RE: **House of Life Ministries**  
**Quaker Heights Rd NW**  
**Conceptual Grading Plan Stamp Date 1/20/20**  
**Drainage Report Stamp Date: 1/20/20**  
**Hydrology File: F11D020**

RE: House of Life Ministries (F-11D020)

RE: **House of Life Ministries**  
**Quaker Heights Rd NW**  
**Conceptual Grading Plan Stamp Date 1/2/20**  
**Drainage Report Stamp Date: 1/2/20**  
**Hydrology File: F11D020**

DRAINAGE NARRATIVE:

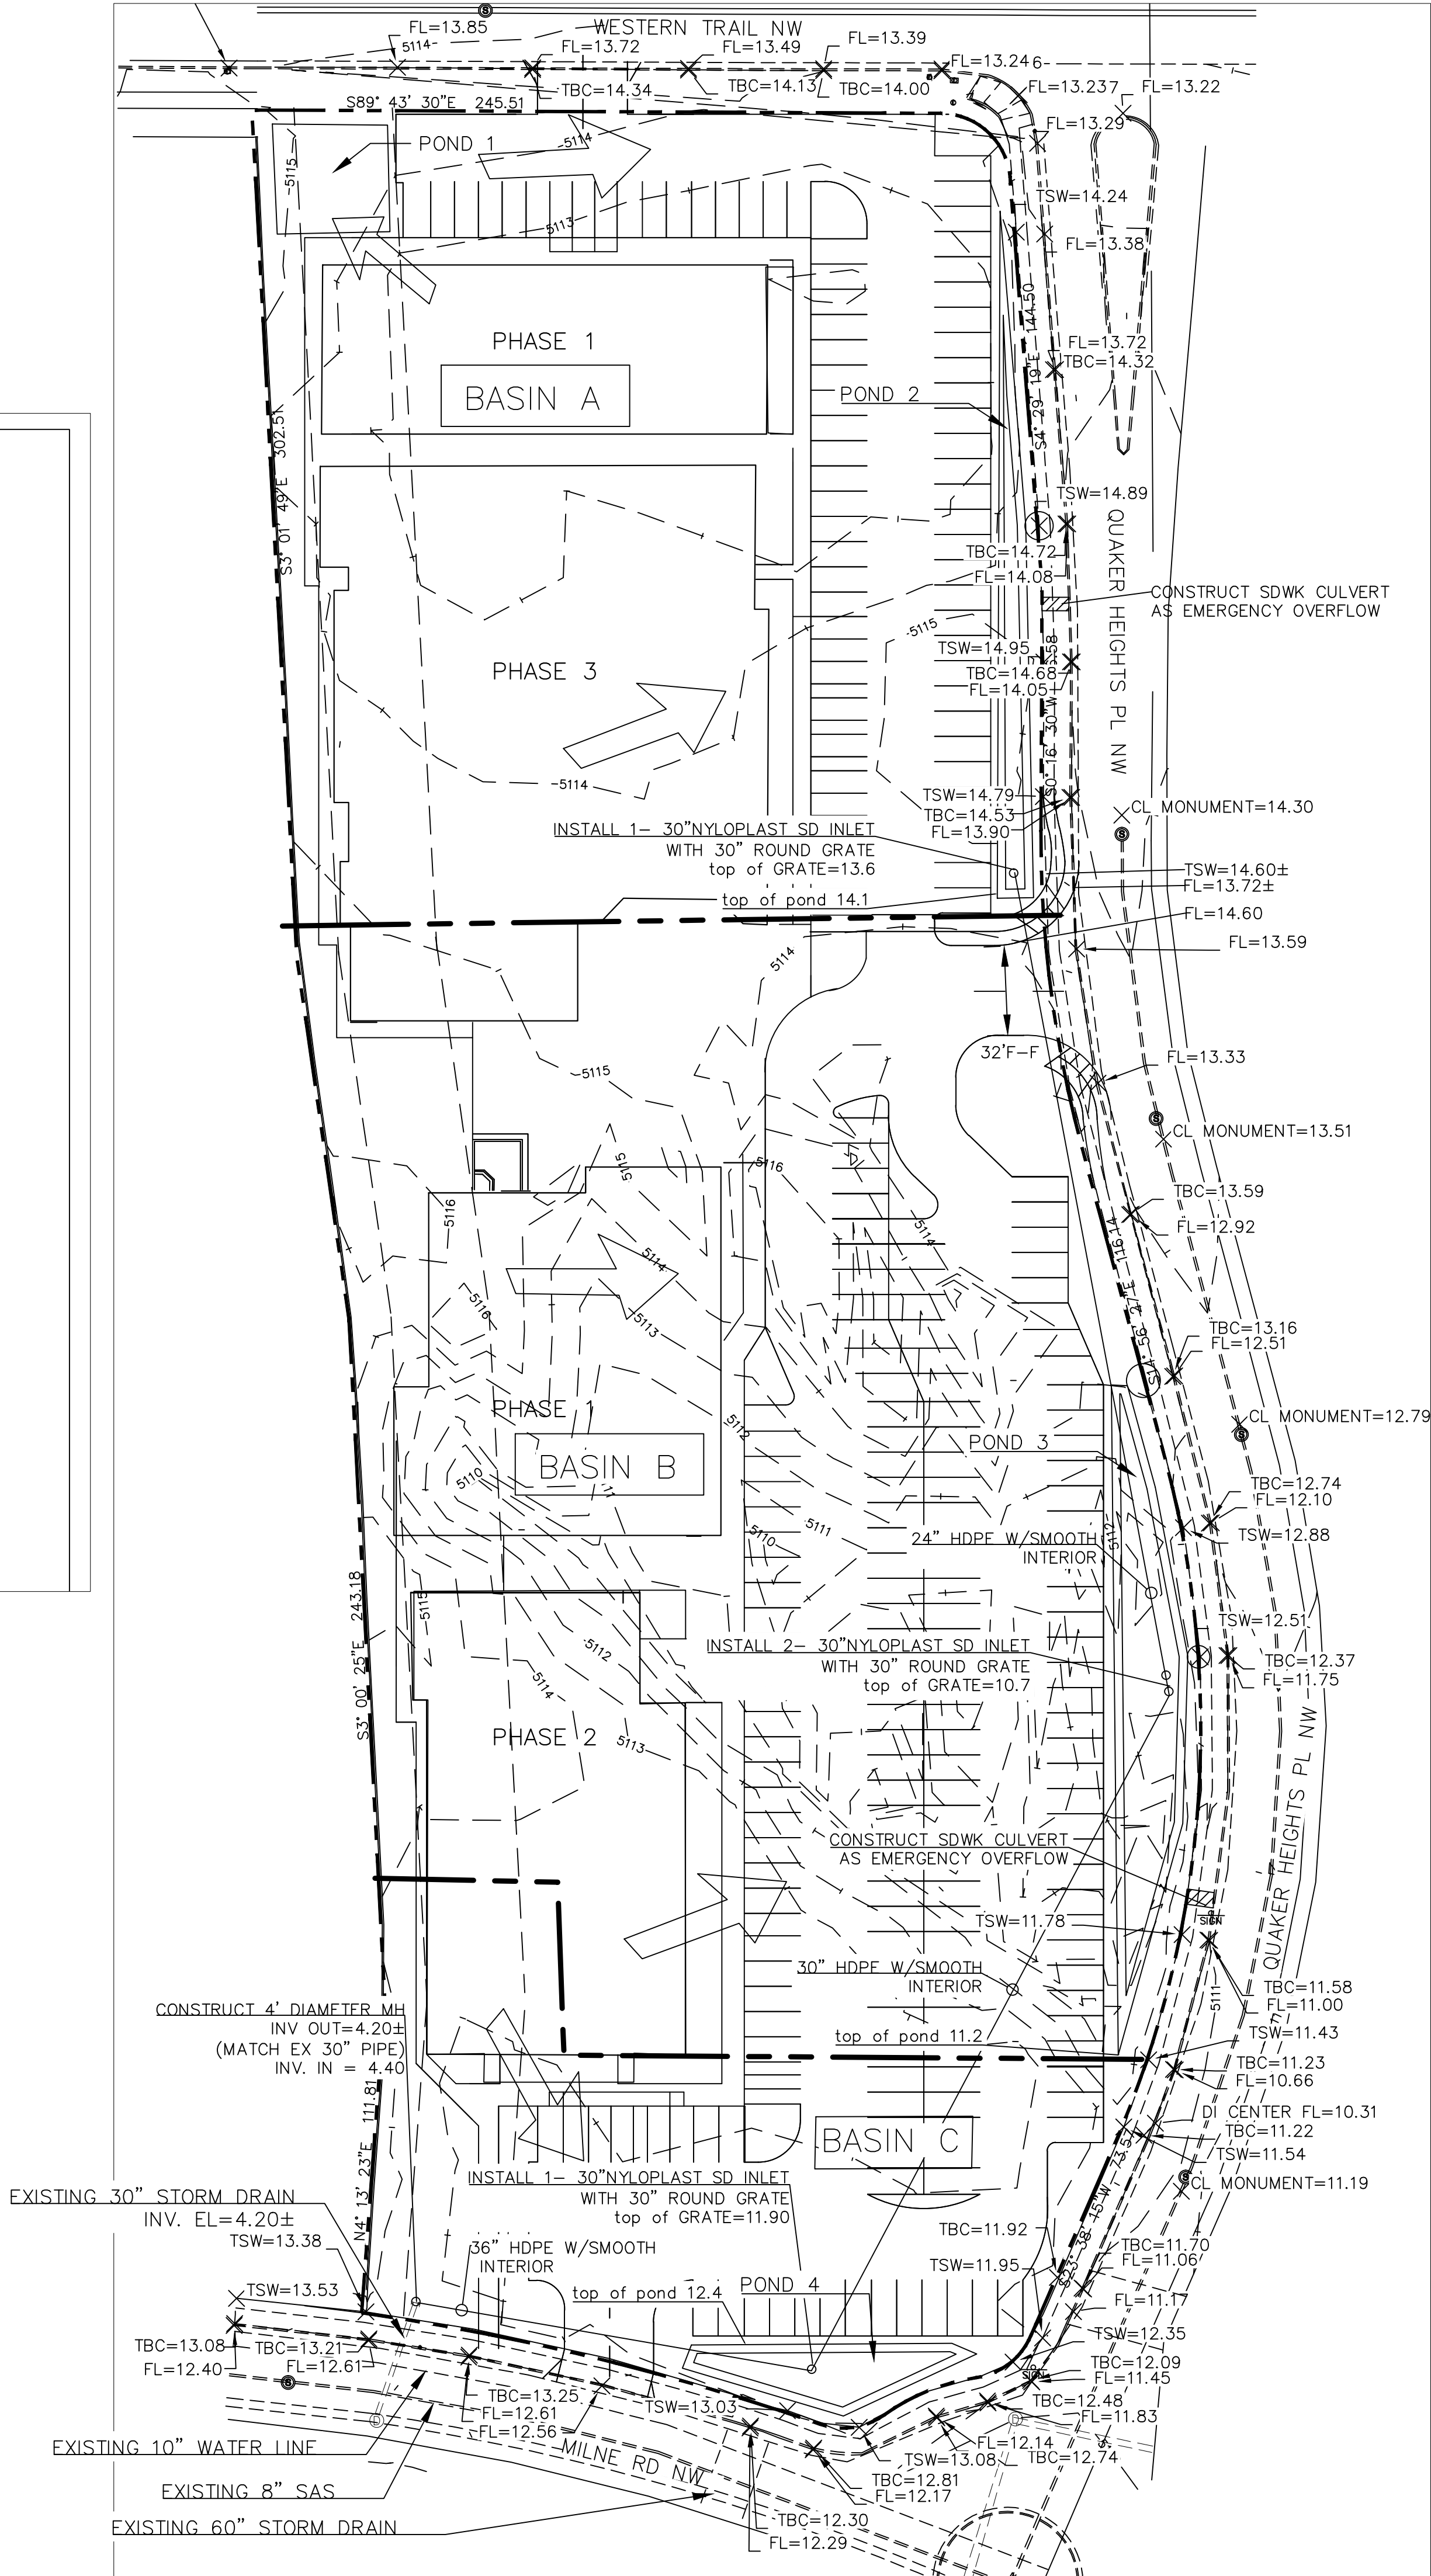
PO Box 1293  
Based on the submittal received on 1/7/20, this project cannot be approved until the following corrections are made:

1. Will the sidewalk culvert be built by SO-19 or Work Order? Please label/provide notes as appropriate.
2. Provide proposed grading, finished floors, and spot elevations throughout the site.
3. The site must discharge in accordance with the approved master plan. Accounting for pond routing and stormwater quality volume will probably get within the allowable discharge and volume, but this analysis needs to be presented.
4. Please provide the SWQV calculations for each basin draining to each pond. The stormwater quality ponds need to be sized for the areas draining to them.
5. Please number the ponds and include a label on each with the SWQV and elevation, the 100-year volume and elevation, and the peak 100 year inflow and outflow.

1. The sidewalk culverts are to be constructed with SO-19. I have noted this on the plan adjacent to the construction note. The SO-19 notes have not been added at this time, and will need to be done when the grading and drainage plan for each phase is submitted.

2. Rough finish floor elevations have been added, along with contour lines to provide better clarity to this conceptual plan. Since a subsequent grading and drainage plan will need to be submitted for each phase, more detail will need to be provided at that time. A note on the plan has been added to indicate this.

3. As you correctly indicated, the pond routing did reduce the outflow of this site so that it does conform with the approved master plan for this area. The outflow rate is 19.28cfs and the permitted flows are 19.40cfs. The allowable discharge per the master plan is .807ac-ft and the calculated amount is .80ac-ft.

4. The requested calculations have been added to the plan.
5. The ponding information has been added to the plan in a table format.
